ATTACHMENT 1

In order to finalise the Department's assessment, additional information is required including but not limited to the following:

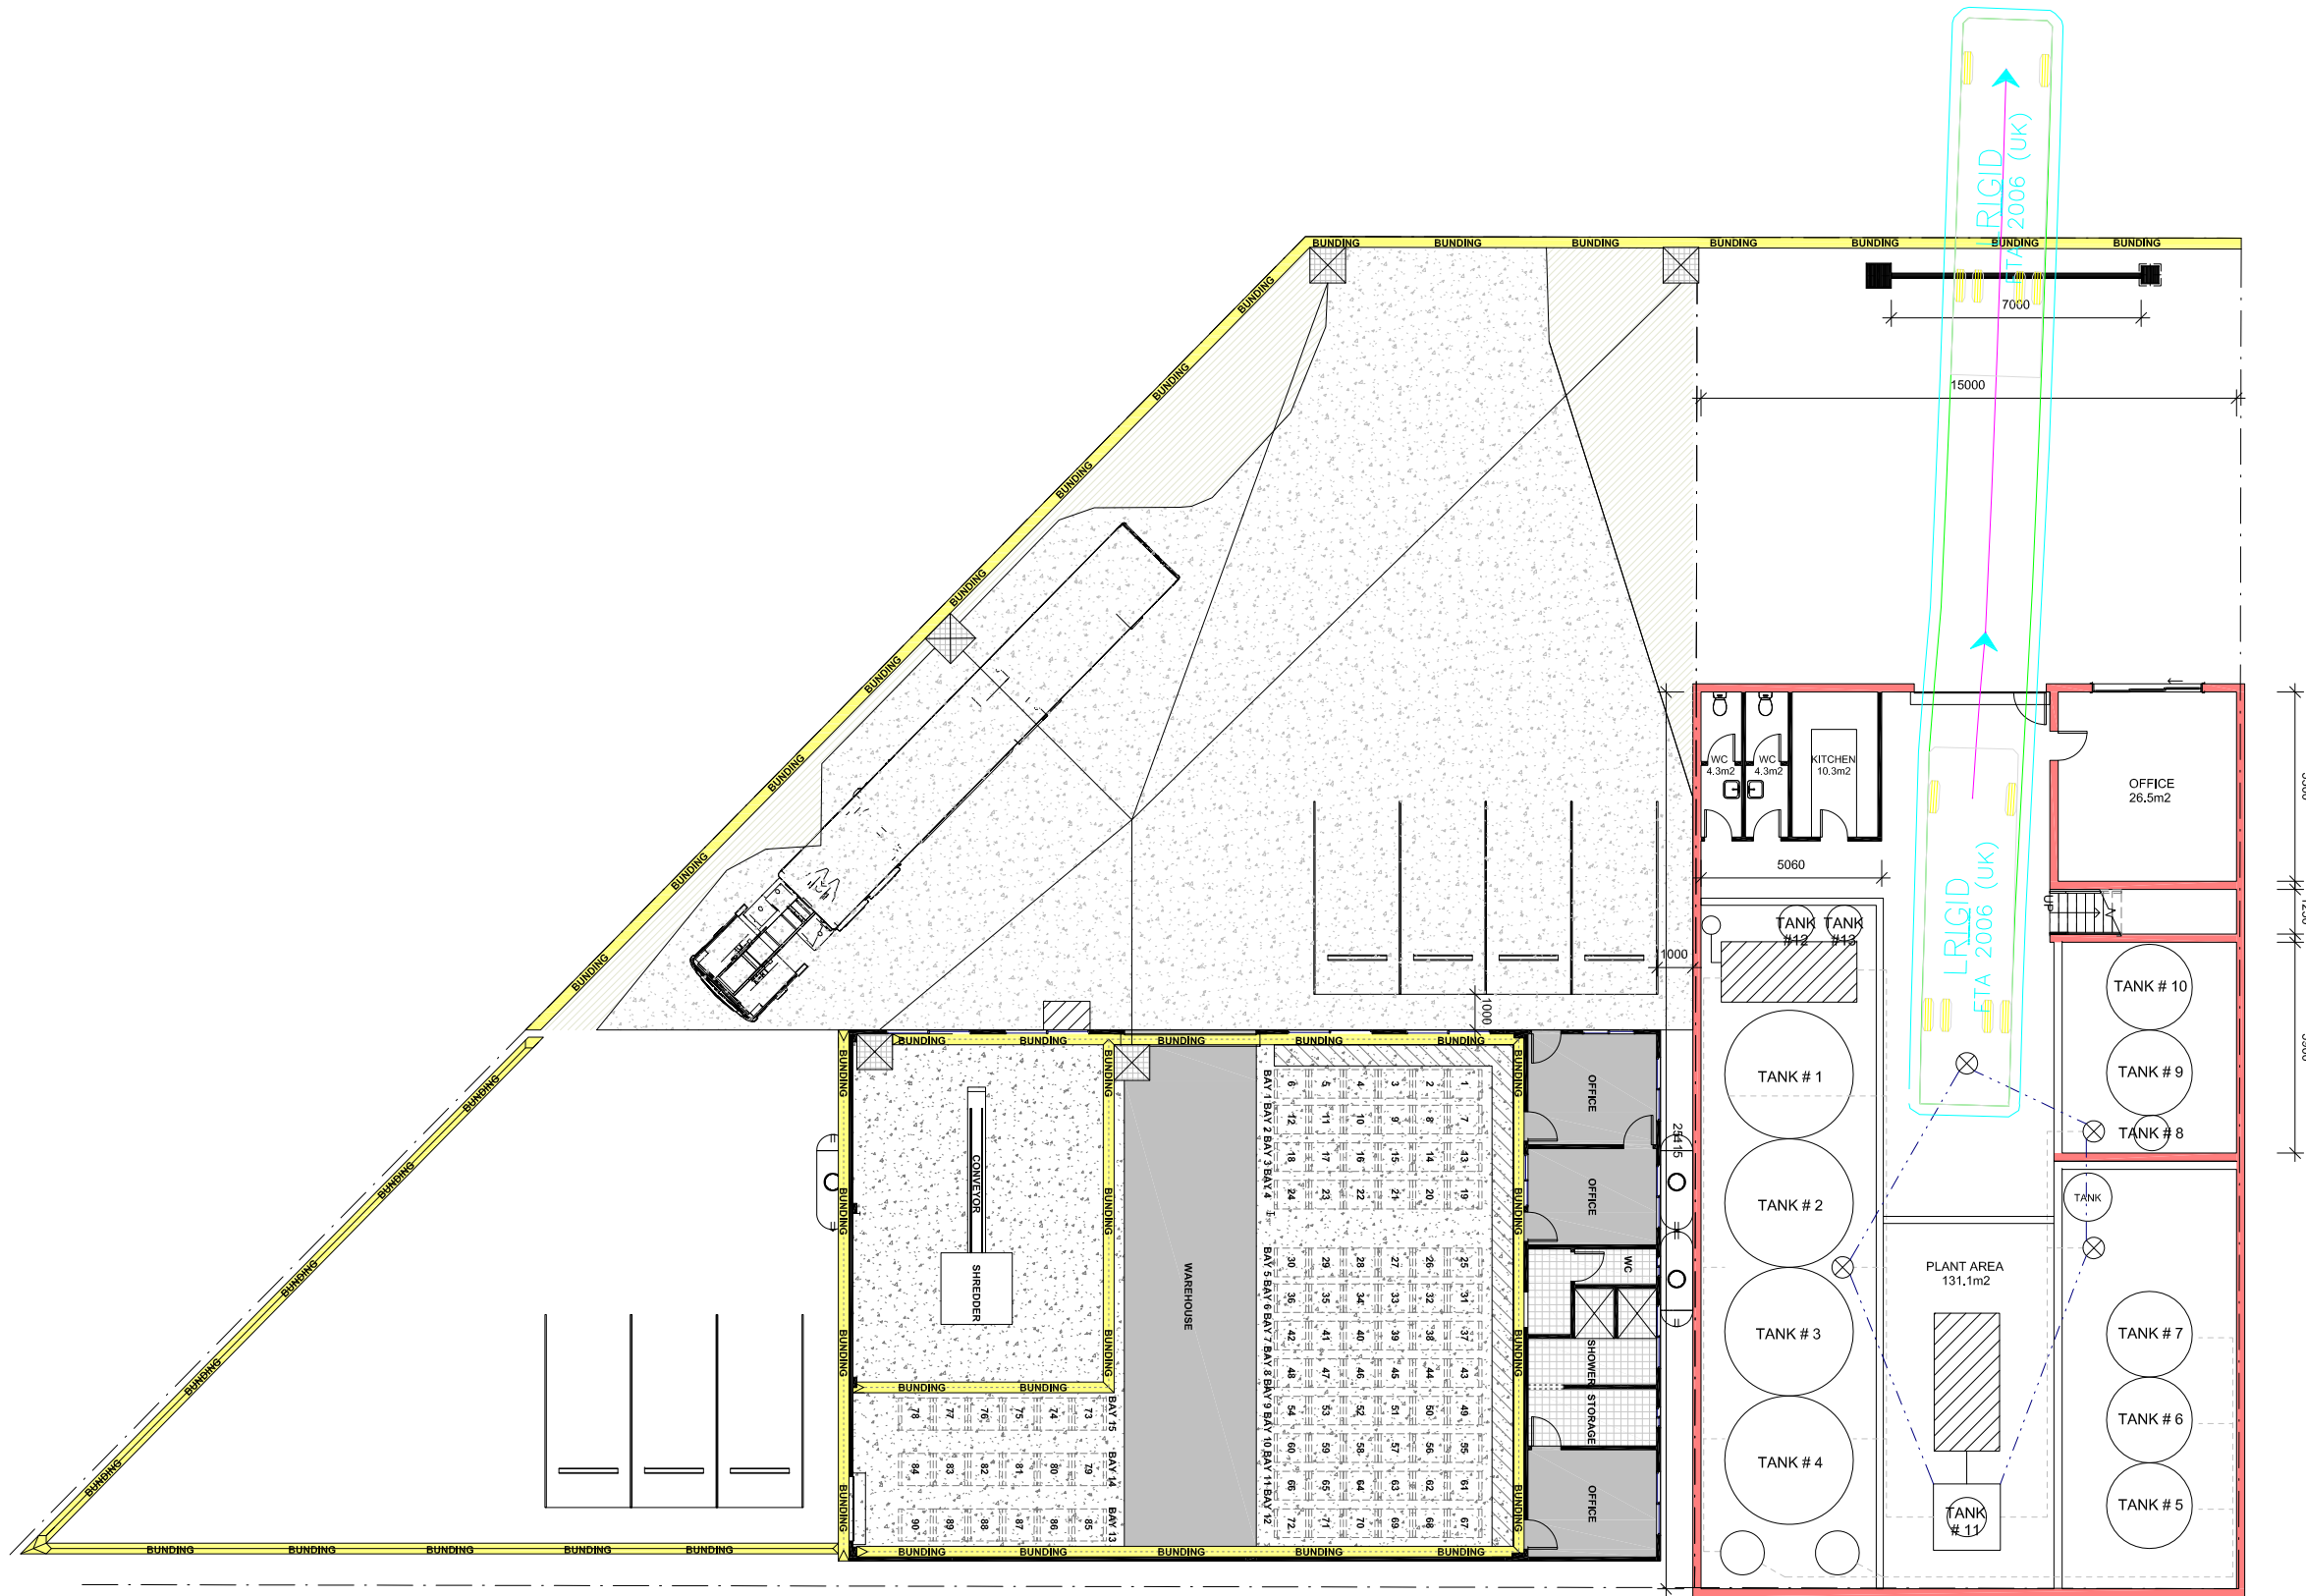
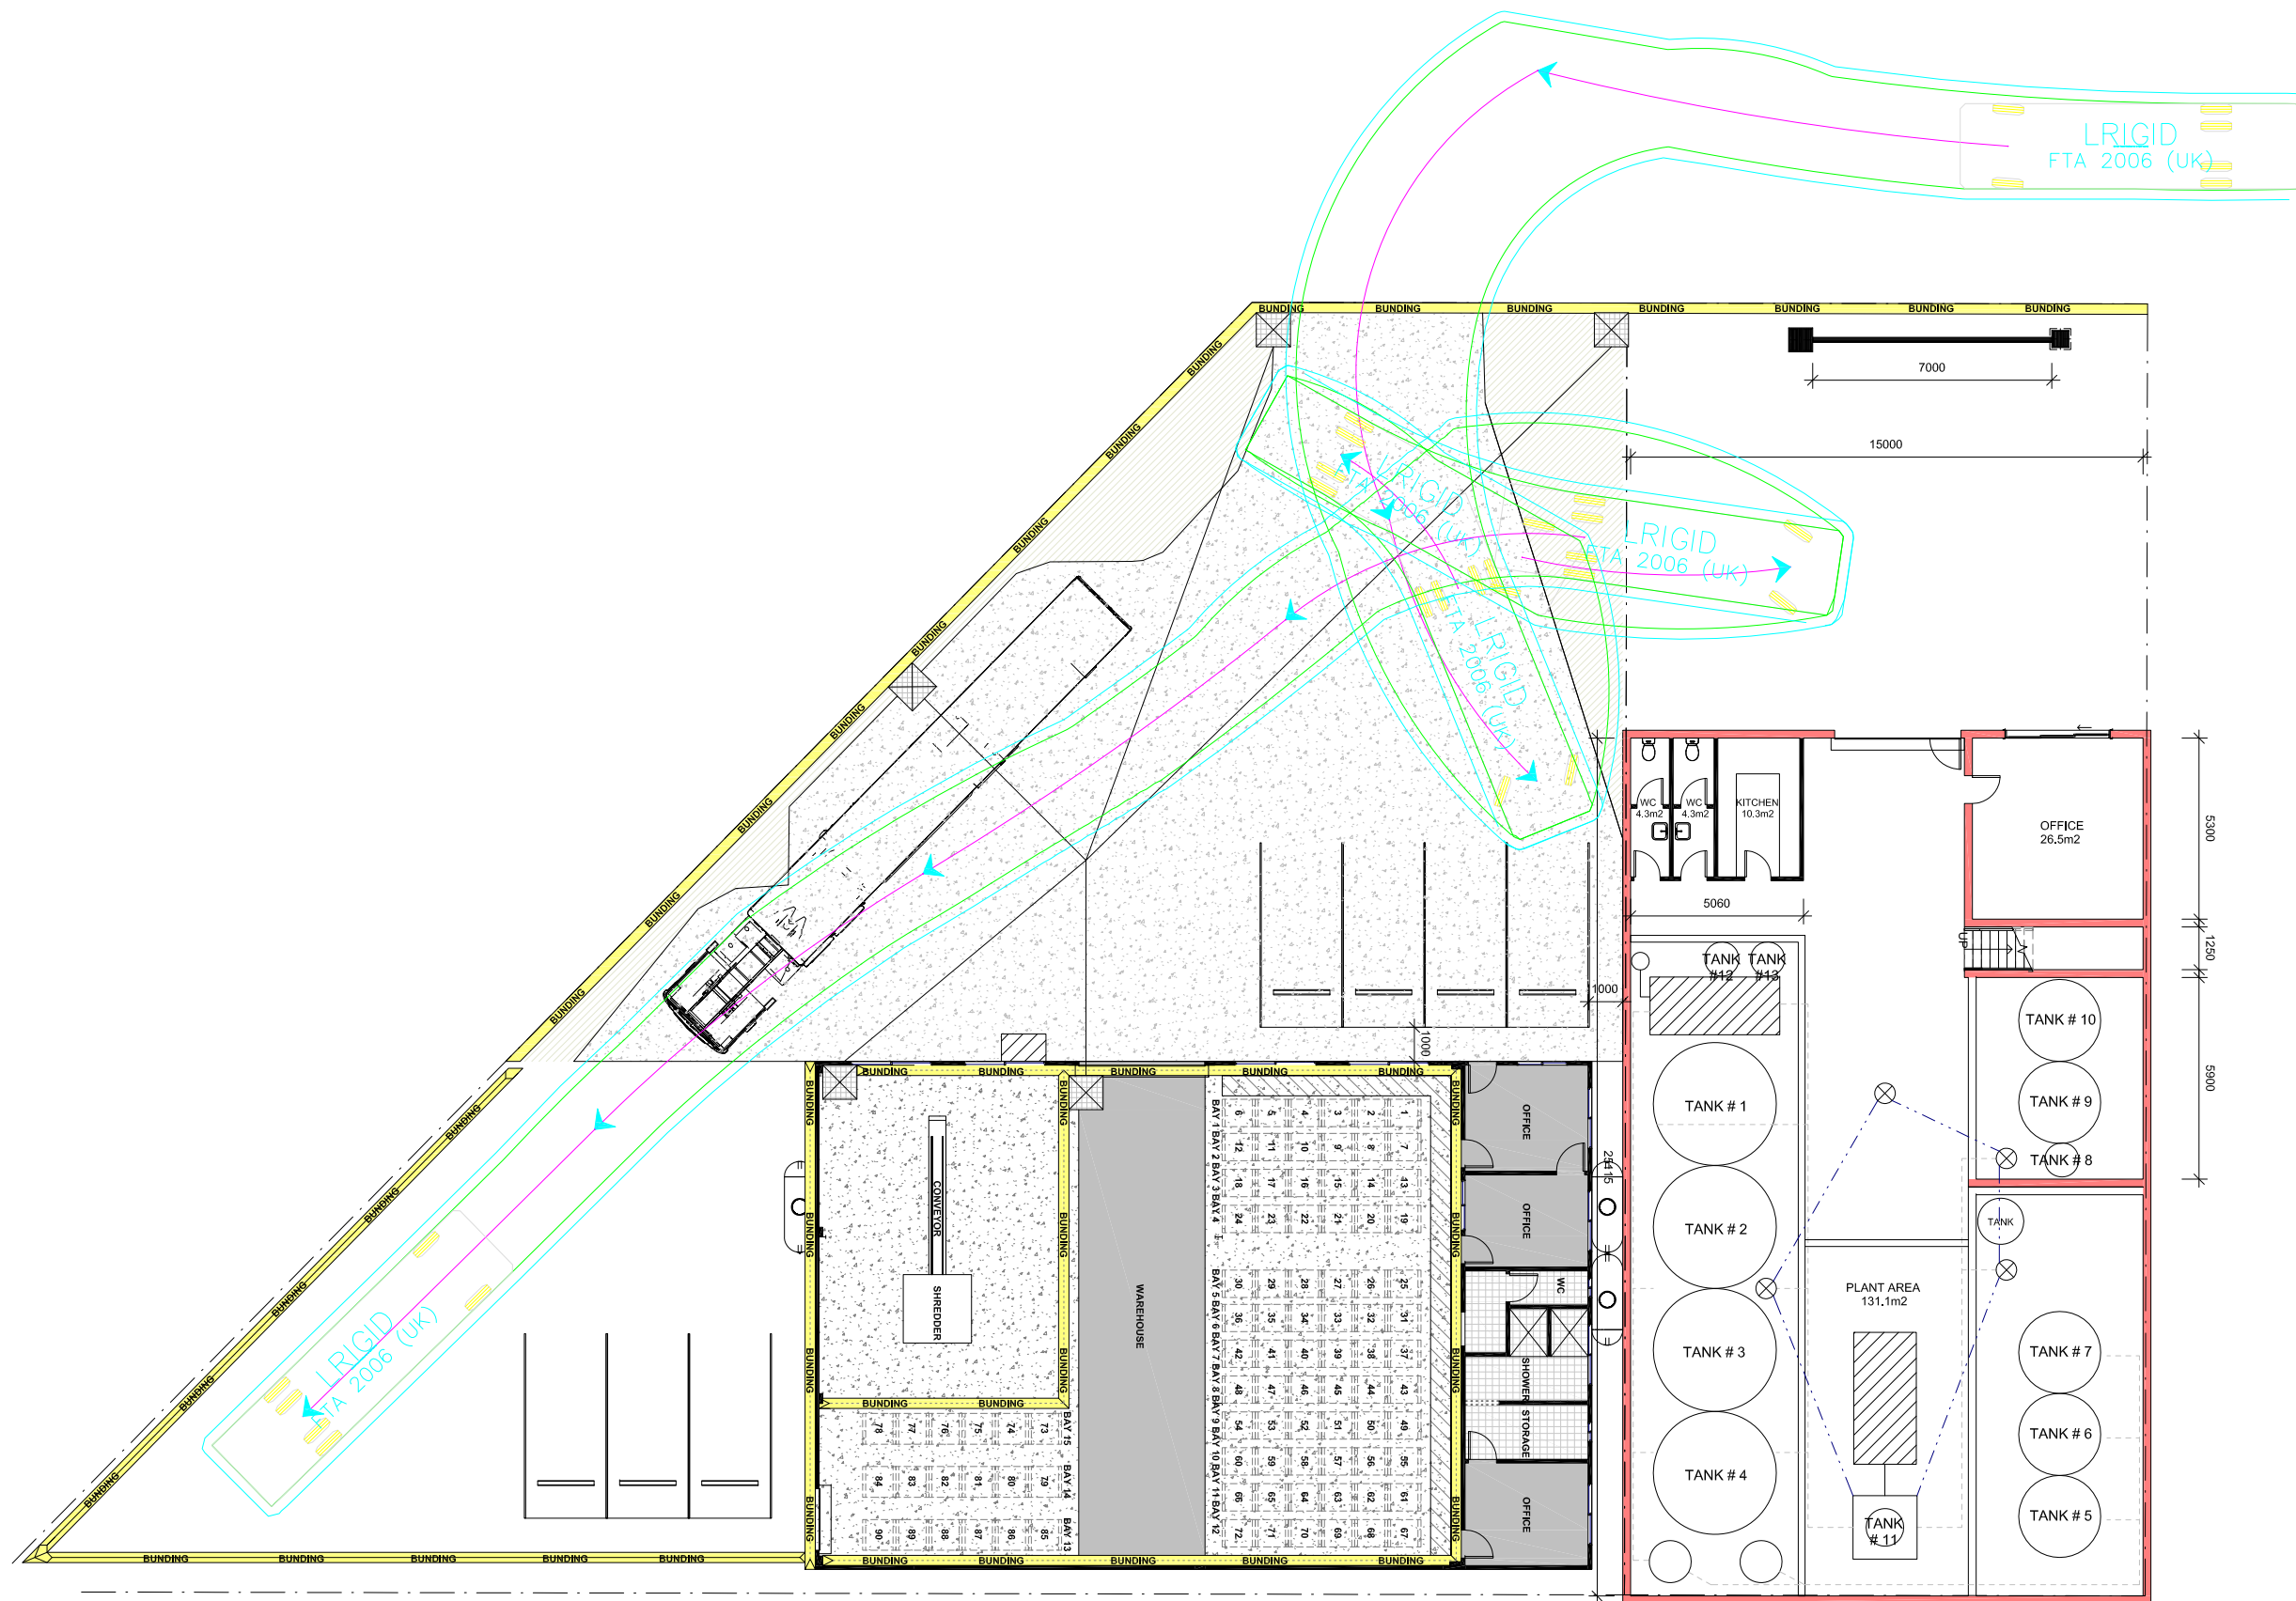
- Previous advice provided by the Department and Council to the Applicant has outlined that the internal swept path movements are not appropriate and need to be updated to demonstrate that turning paths would not encroach onto Council footpath, nature strip or any other infrastructure located on Council land. It is noted that the advice has not been considered in the EIS, it is required that mitigation measures and/or alternatives need to be considered and subsequently updated to meet Council and the Department's requirements.

- The manoeuvring and turning of the vehicle must be completed within the site and must not cause encroachment into nature strip or the footpath. The swept path diagrams demonstrate otherwise with the encroachment into nature strip. As per previous correspondence the Department requested the proponent consult with Council to resolve internal swept path movements satisfactorily. Please provide further evidence of any further consultation with Council regarding the outcome and resolution of these issues.

- The EIS notes that vehicle transporting waste to and from the sites can carry between 2,000 and 30,000 litres (L) of materials and notes that the majority of vehicles accessing the site are owned and operated by the Applicant, however the provided vehicle and truck register (Appendix 8) shows a list of existing truck fleet owned by the Applicant range in carrying capacity from 2,000 to 15,000L. Please clarify how the Applicant intends to transport 30,000 L of waste. It is also noted that vehicles carrying 30,000 L of waste is anticipated to be longer than the 10 metre vehicles assessed in the swept path analysis in the Traffic Impact Assessment (TIA).
